Harnett County Government Complex
307 W. Cornelius Harnett Boulevard
Lillington, NC 27546

Re: Status of Improvement Permit Application: BRES2009-0066

An attempt was made to evaluate your property for the purpose of issuing an Improvement Permit. The evaluation could not be completed for one or more of the following reasons.

- * SITE ADDRESS: 15 SPENCER LEE LANE
ERWIN, NC 28339
- * OWNER: BVA ENTERPRISES, INC.
1300 BENSON RD STE 108
GARNER NC 27529-4686
- * THIS PLOT PLAN IS FOR PRECONSTRUCTION
PURPOSES ONLY.

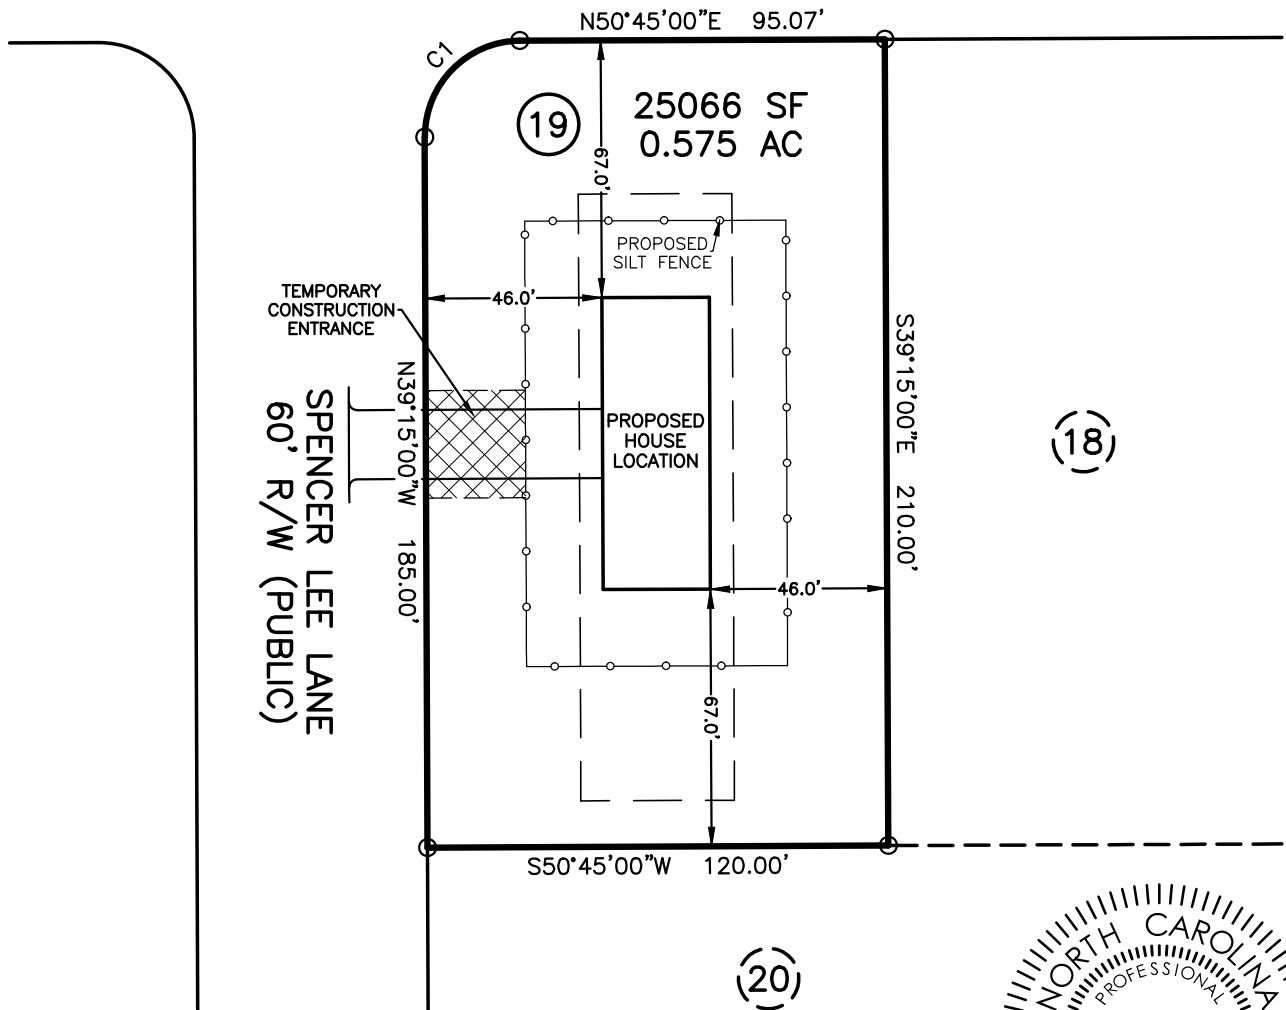
1. Use pink flags to mark property lines and irons that are set by surveyor need to be visible. (*\$25.00 fee incurred*)
2. Use orange flags to mark house corners (*\$25.00 fee incurred*)
3. Directions not clear to property (*\$25.00 fee incurred*)
4. Property needs only brush or vegetation removed
5. Driveway not shown on site plan
6. Backhoe pits required
7. Other- **House box shall be flagged onsite. Site plan incorrect. Side measurements of 16.5ft do not add up length of property. Site plan shall be revised to show correct side setbacks. Revise and reconfirm when ready.**
